To:	Department of Planning, Industry and Environment – Industrial Assessments
Cc:	Mirvac Industrial
From:	Jacqueline Parker, Grace Macdonald – Urbis
Email:	<a href="mailto:jparker@urbis.com.au">jparker@urbis.com.au</a> , <a href="mailto:grace.macdonald@urbis.com.au">grace.macdonald@urbis.com.au</a>
Date:	9 November 2020
Subject:	Aspect Industrial Estate – Strategic Planning Considerations

**ATTACHMENT: DRAFT AIE CONCEPT AND STAGE 1 PLAN MARK-UP**

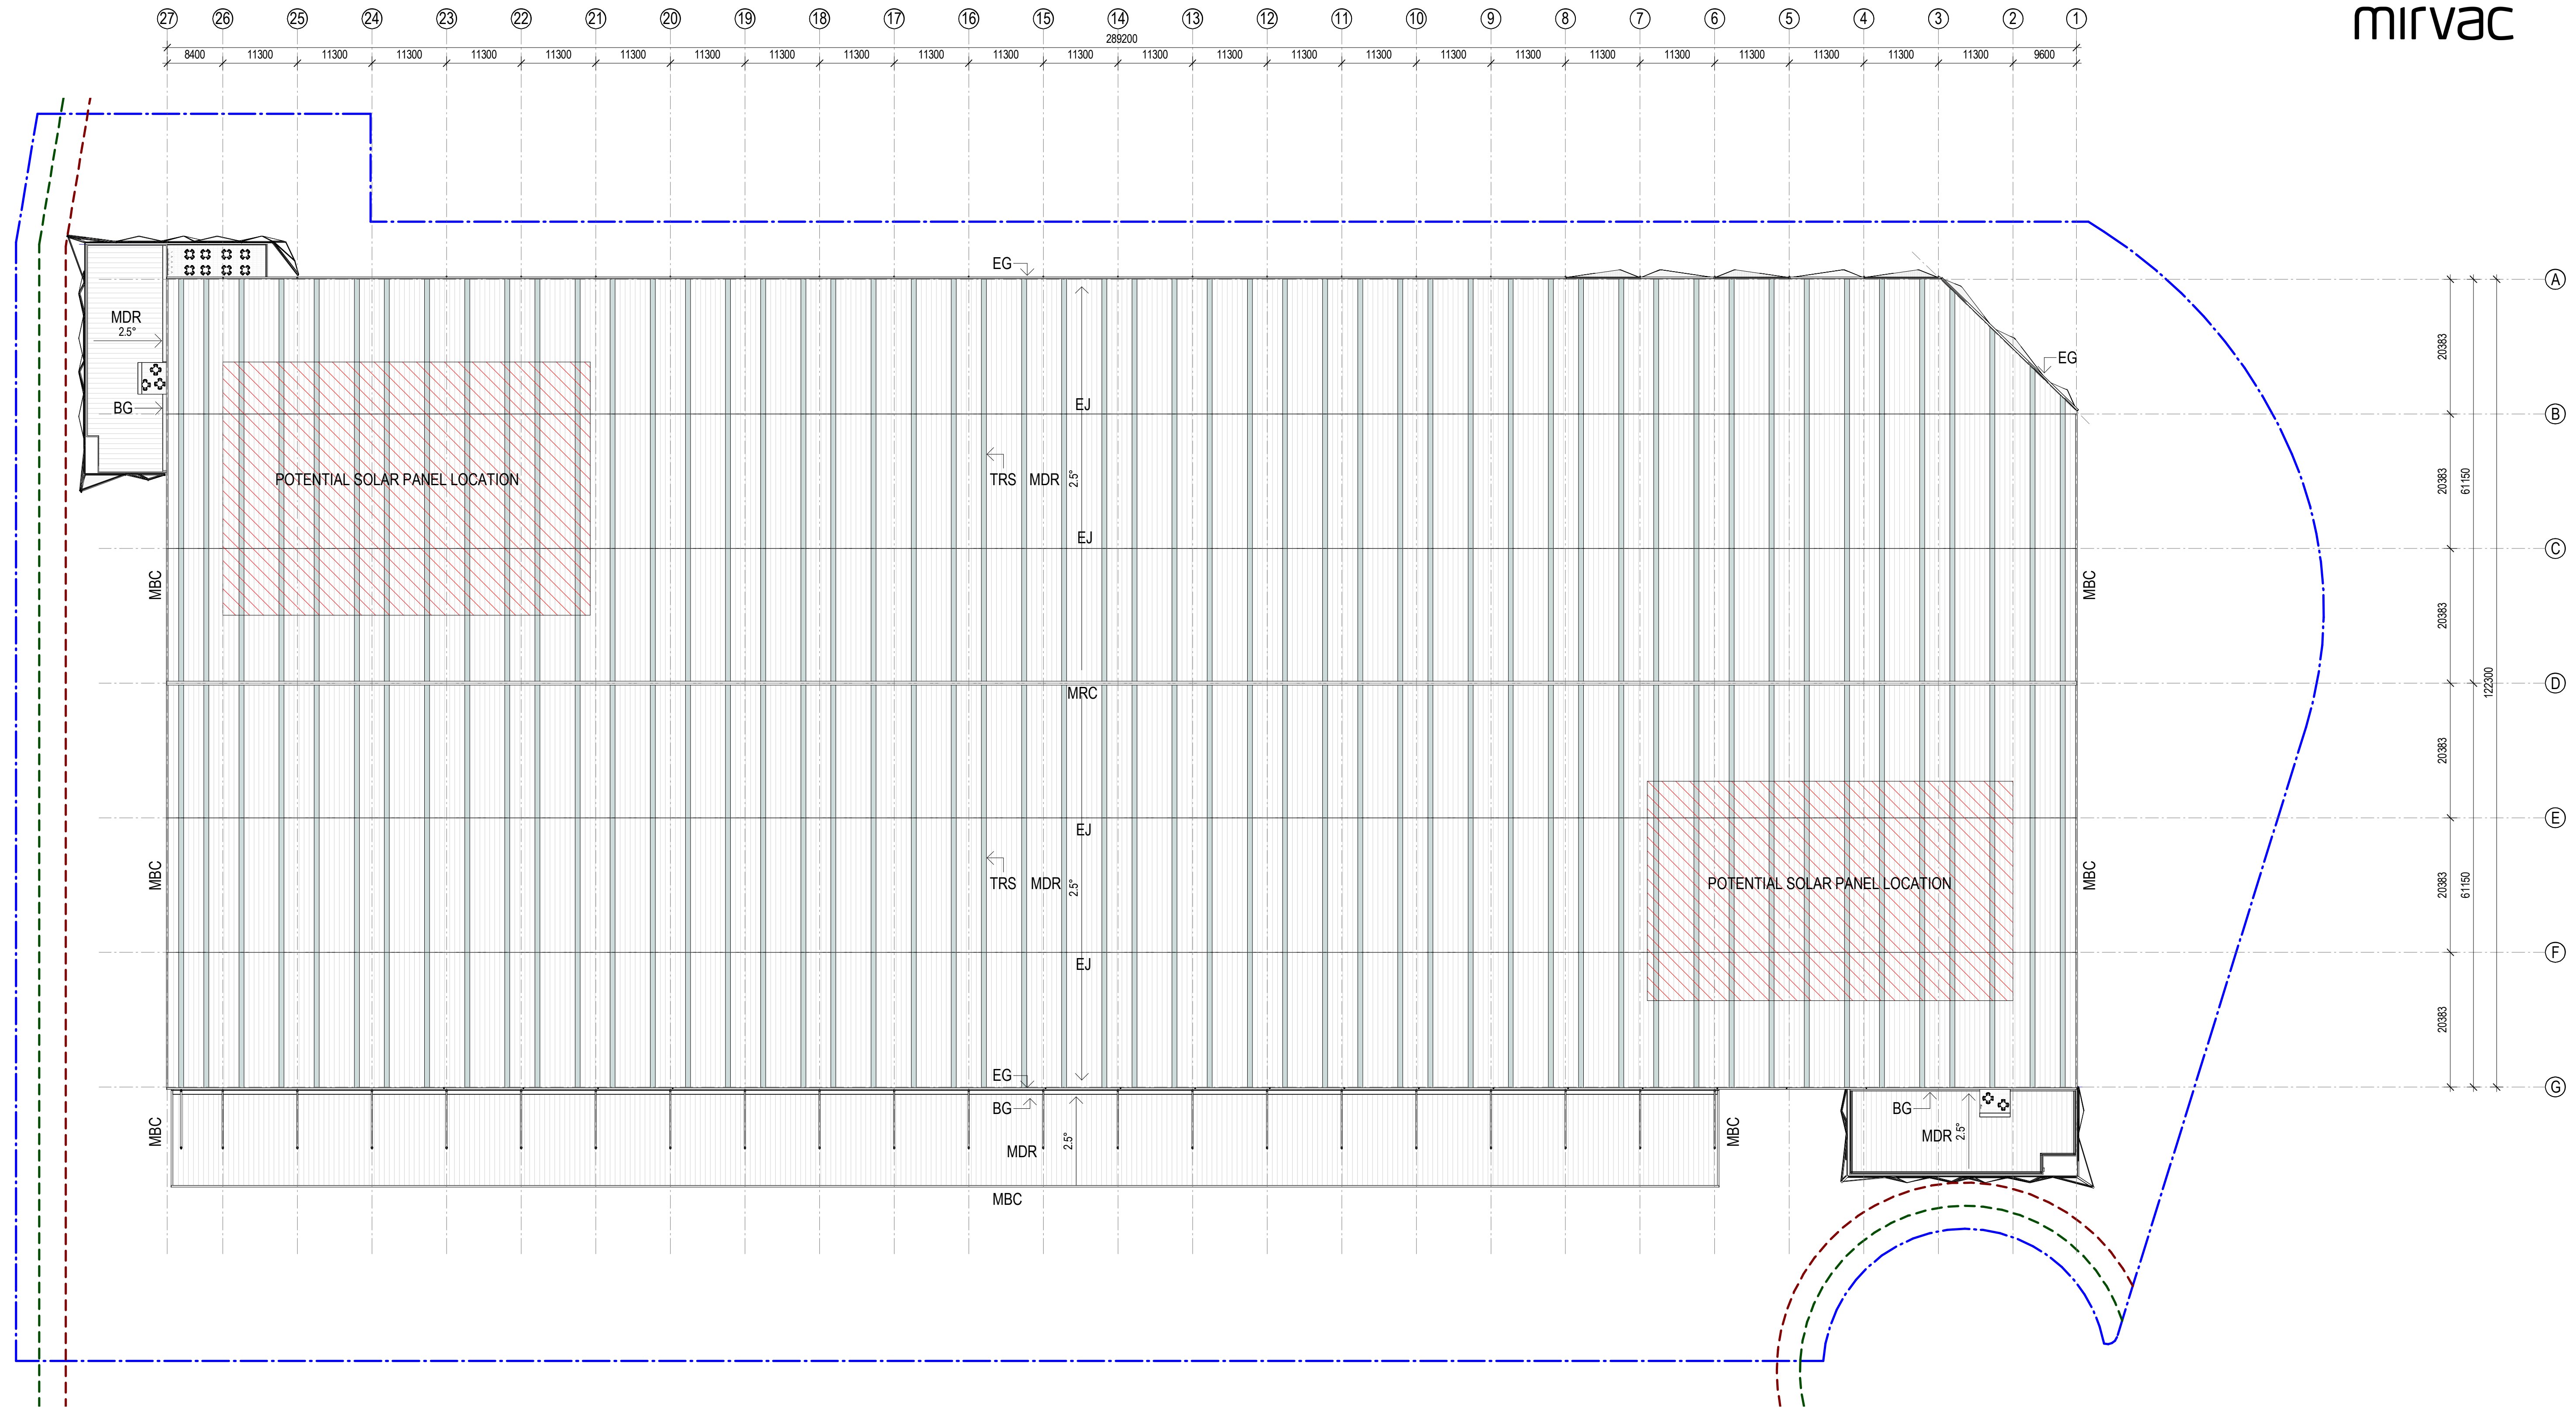
DPIE TOA Feedback	Mitigation Measure
<p><b>Access Road 1 width and access points</b></p> <p>The draft DCP proposes a width of 30.6m at Mamre Road/Access Road 1 intersection with a potential</p>	<ul style="list-style-type: none"> <li>Current AIE SSD documentation currently proposes a Road No.1 width of 24.5m mid-block with signalised intersection matching the TfNSW strategic documentation. If Road No.1 requires a 26.4m mid-block road reserve width,</li> </ul>

DPIE TOA Feedback	Mitigation Measure
<p>mid-block width reduction to 26.4m, subject to design and Council agreement.</p> <p>The road No.1 is 'accessed denied' meaning car parking access and loading dock access should not be provided to/from this road.</p>	<p>this additional 0.9m will be widened to the south. Widening to the South ensures AIE SSD Stage 1 development will not be impacted as a result of road reserve widths.</p> <ul style="list-style-type: none"> <li>▪ The current application proposes direct connection to/from Road No.1. Should Road No.1 be 'access denied', access to car parking and hardstands from Road 01 can be removed which is considered a minor amendment. These amendments will not substantially affect the concept plan of the estate and can be addressed during the Response to Submissions phase.</li> <li>▪ It is understood traffic modelling for Mamre Road Precinct is anticipated to be completed in early 2021 and that this modelling will confirm access requirements to key roads throughout the precinct, including AIE Road No.1. Modelling updates can be responded to through the Response to Submissions phase.</li> </ul>
